RE: **Gonzales Residence**
Lot 11 Blk 10 Unit 22 Volcano Cliffs
6308 Petirrojo NW
Grading and Drainage Plan
Engineers Stamp Date 12/14/15 (D10D003F11)

**RE: Drainage Resubmittal
Gonzales Residence- (D10D0003F11)
Albuquerque, New Mexico**

**RE: Gonzales Residence Lot 11 Block 10 Unit 22 Volcano Cliffs
6308 Petirrojo NW
Grading and Drainage Plan
Engineers Stamp Date 12/7/15 (D10D0003F11)**

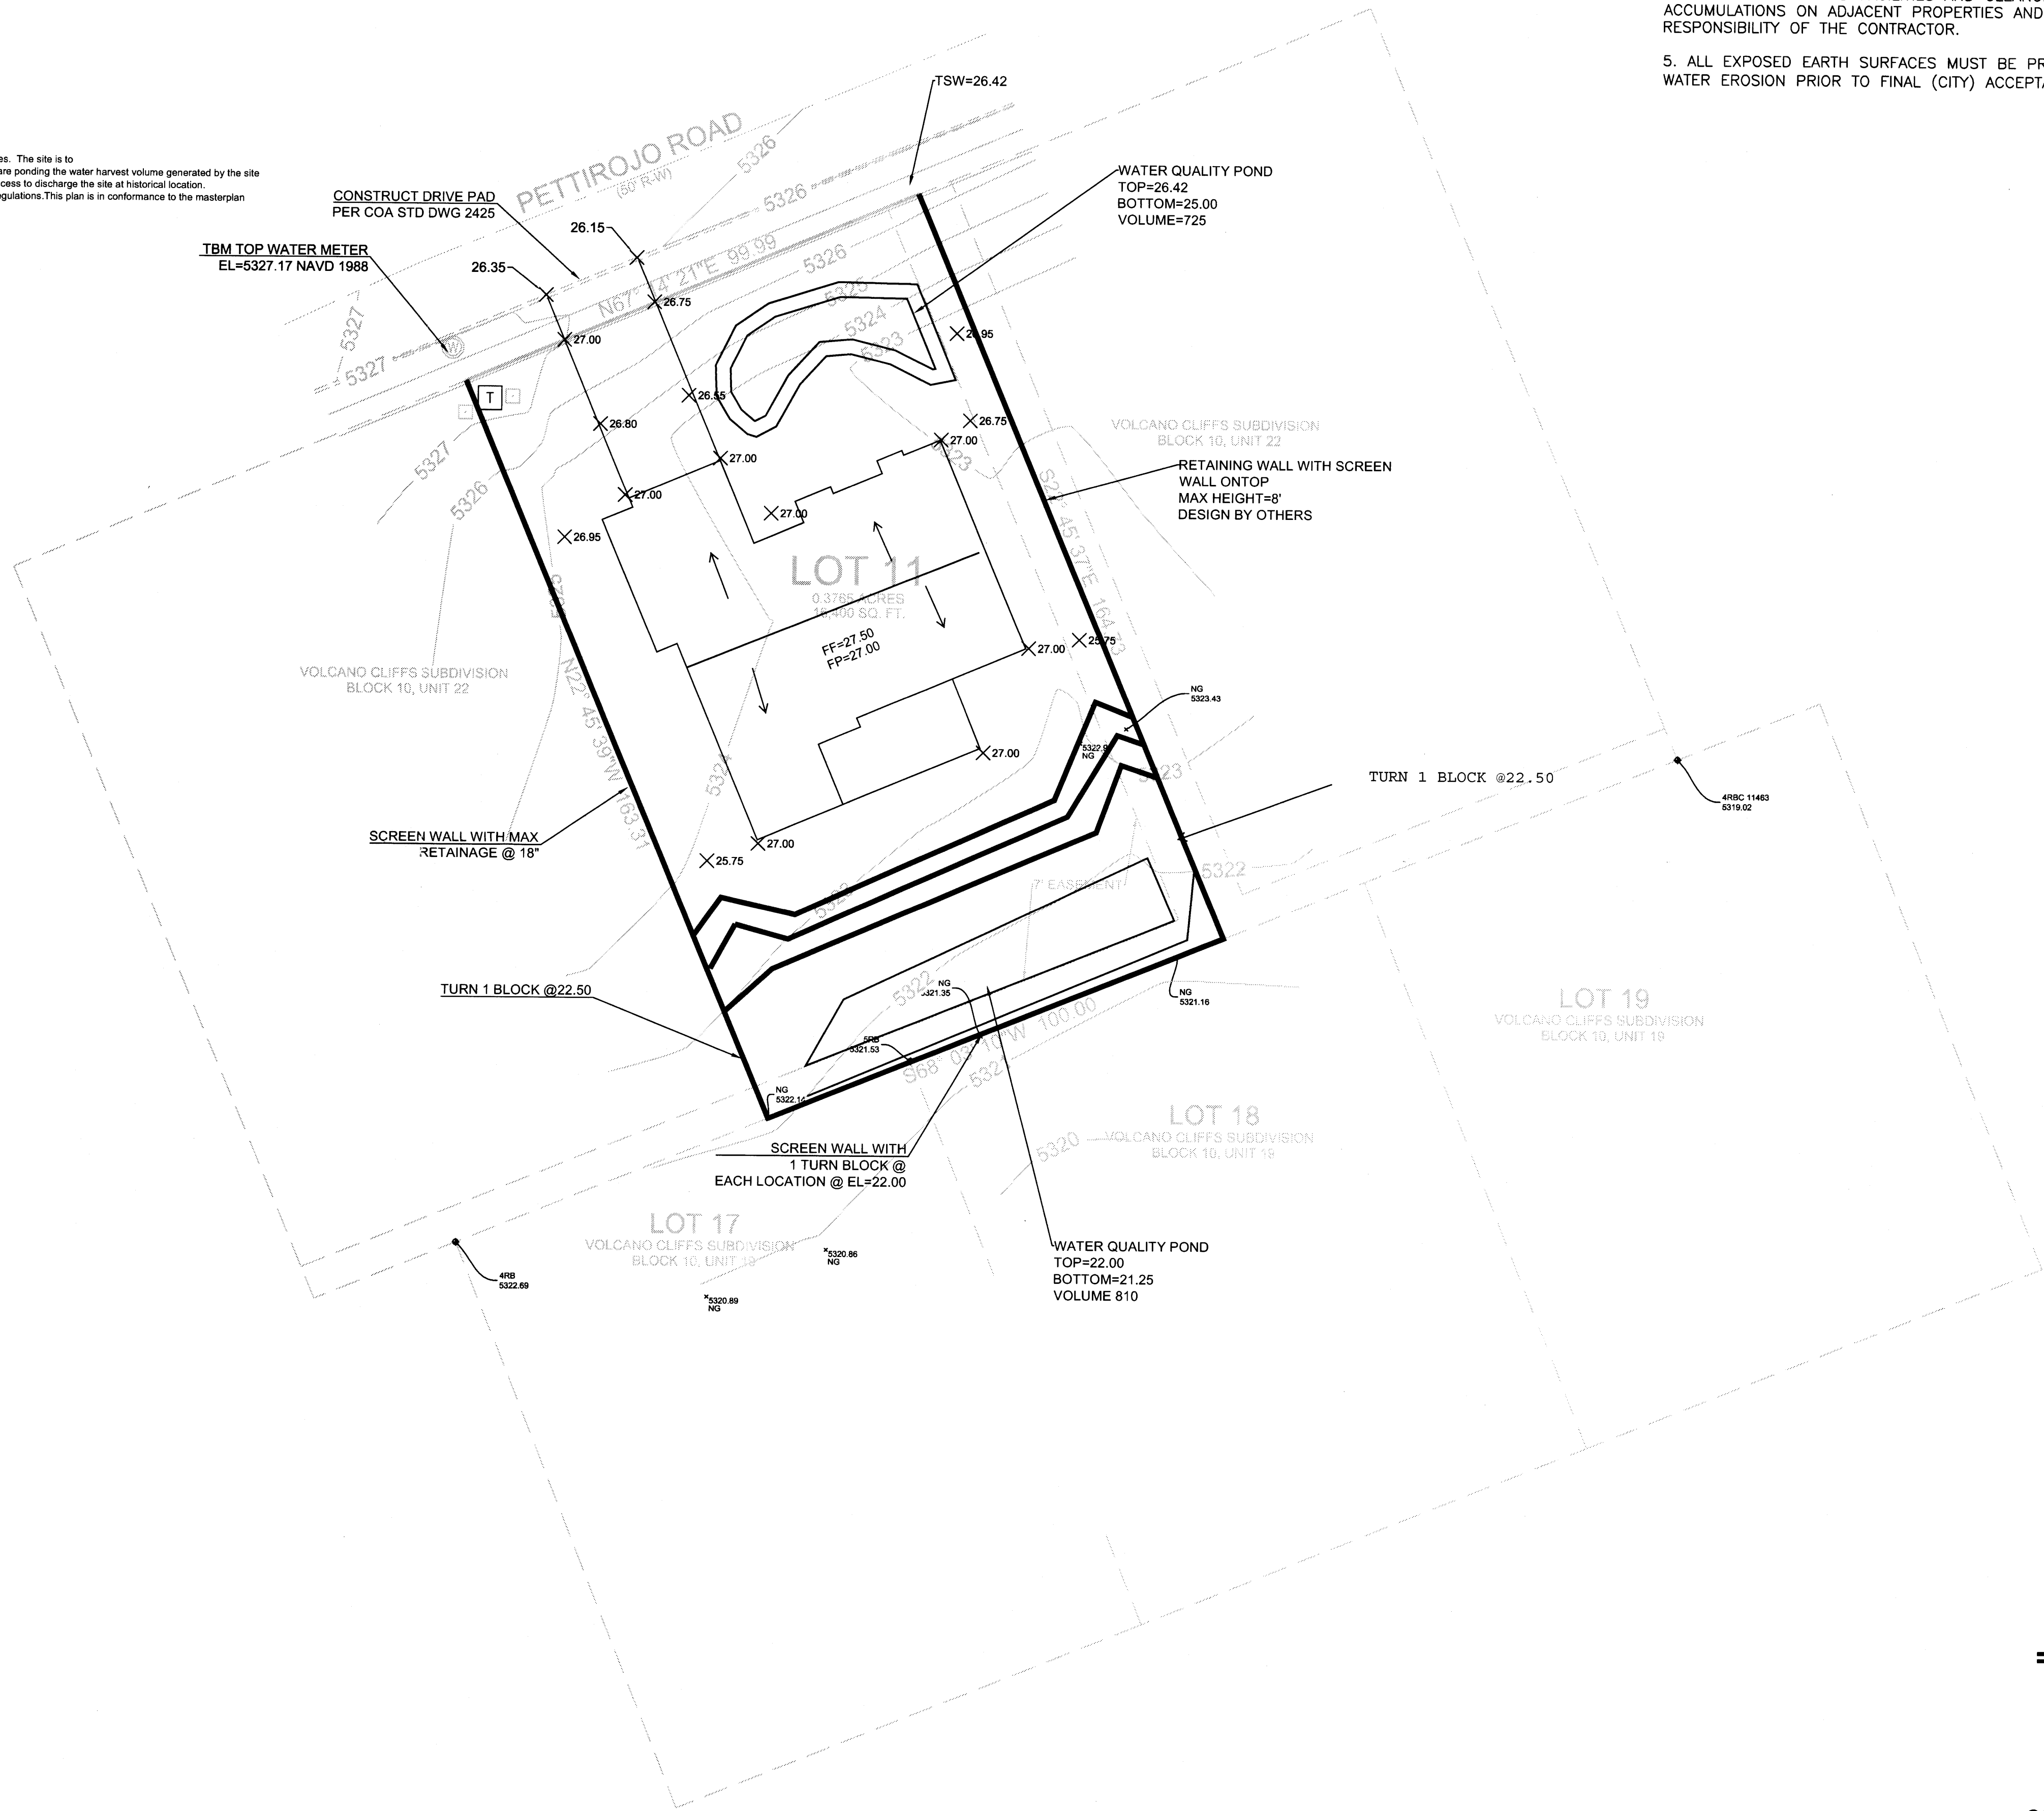
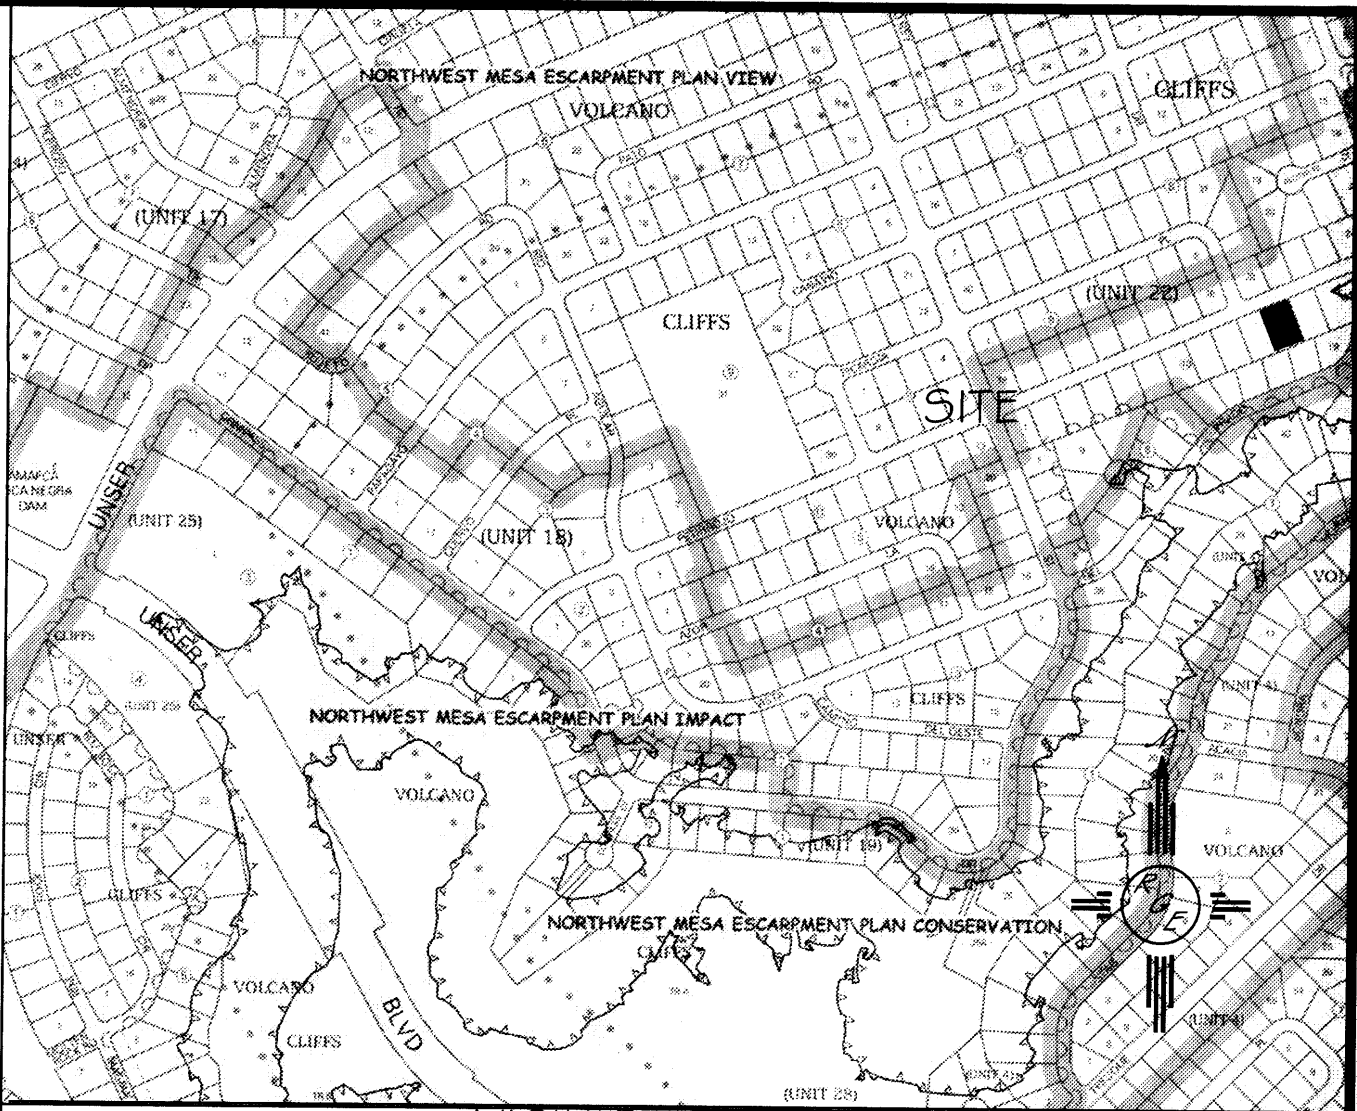
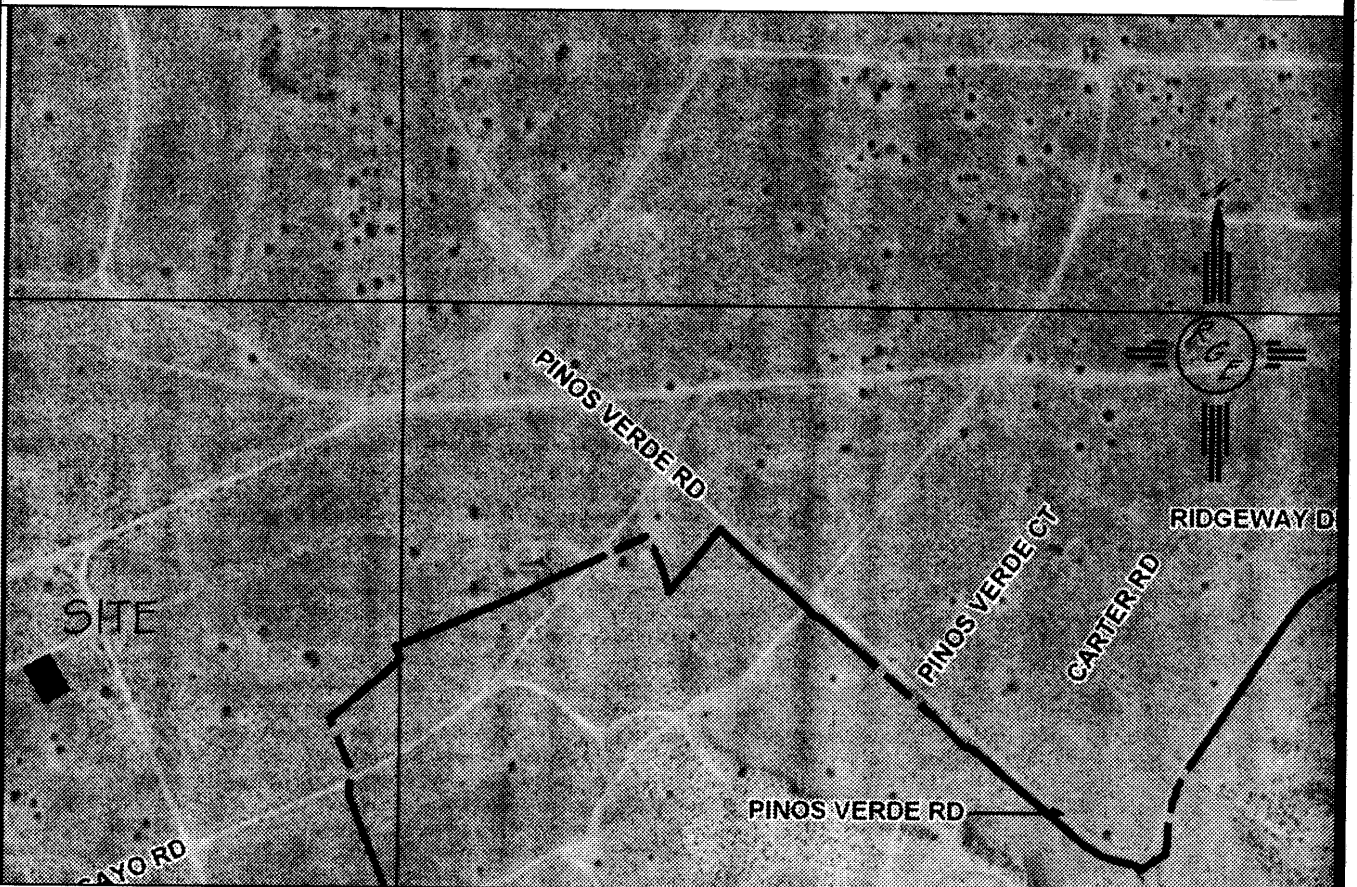
- This lot drains to two different ponds, the front half flows to pond 8 and the back half flows to pond 9, provide a site plan depicting this requirement.
- The turn blocks are located in the wrong fence line, the turn blocks should be placed in the east and west rear yard walls.

1. This lot drains into two basins, the front to pond 8 and the back to pond 9, revise site
We previously had incorrectly located the lot on the wrong block in our analysis. We have revised the plan to conform to the basin map fro SAD 228. We have enclosed this map and identified the lot on the map.
2. The turn blocks are located on wrong fence line. turned blocks should be on east and west
In order to have the site conform to the proposed condition basin map, the pad needs to be elevated. This causes retaining on the east and west property lines. We have added turned block on these walls at the south portion of the lot, where the flow can be accepted and passed. Based upon the existing contours and the location of Pond 9, we propose to have the turn blocks on the south wall remain. This design better matches existing and proposed flow conditions shown in the SAD 228 drainage plan.
